**Re: Section 73 application for variation of a condition to appeal decision ref:
APP/N1920/D/22/3299868/Planning application ref: 22/0057/HSE – 9 Three Valleys Way, WD23
2FF**

On behalf of the applicant we would request that the above approved proposed drawings submitted previously (by others) are replaced by our proposed drawing references: 223075/08, 223075/09 & 223075/10.

FIRST FLOOR PLAN
(1:50)

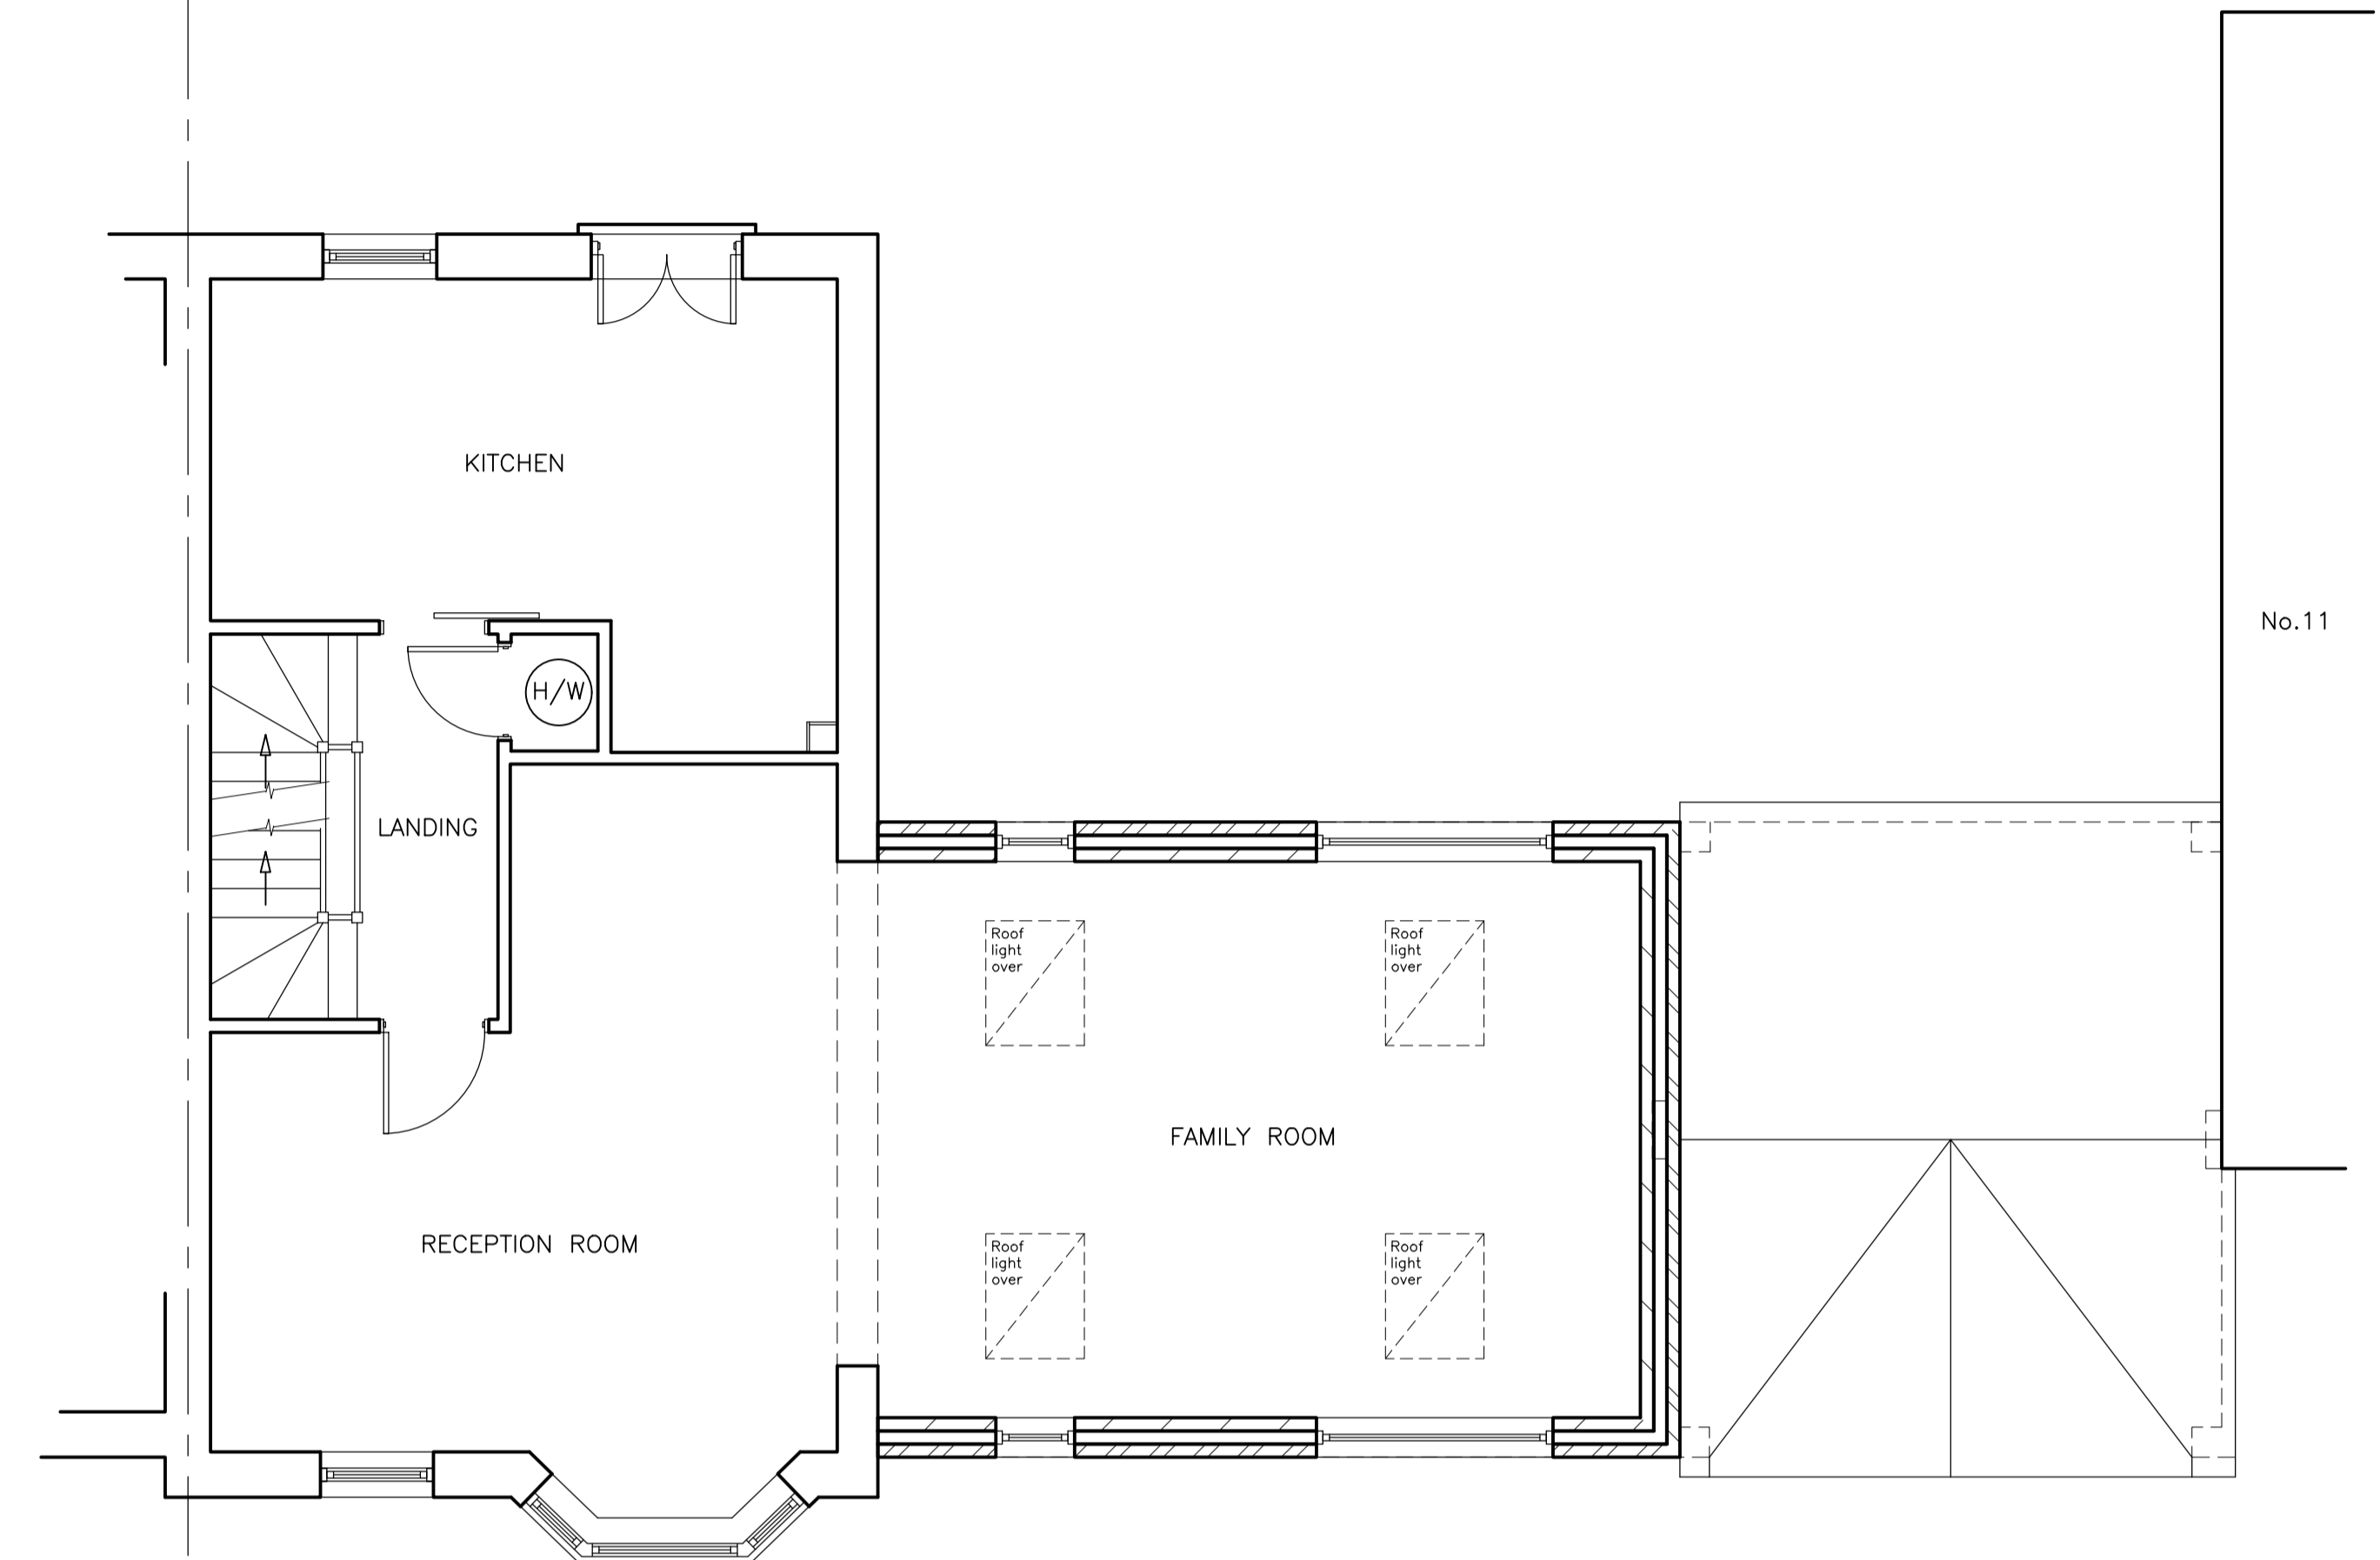
1. Two roof lights have been added to both the front and rear roof slopes to provide additional day light to the first floor.
2. The front wall to the first floor extension has been moved forward approximately 400mm to allow it to be constructed directly over the existing front wall to the garage below. (We note that the previous scheme inset the front wall behind the garage wall slightly which has proved structurally impractical to achieve.)
3. The roof pitches have been altered slightly in order to keep the proposed eaves and ridge heights as previously proposed and accommodate the 400mm depth.
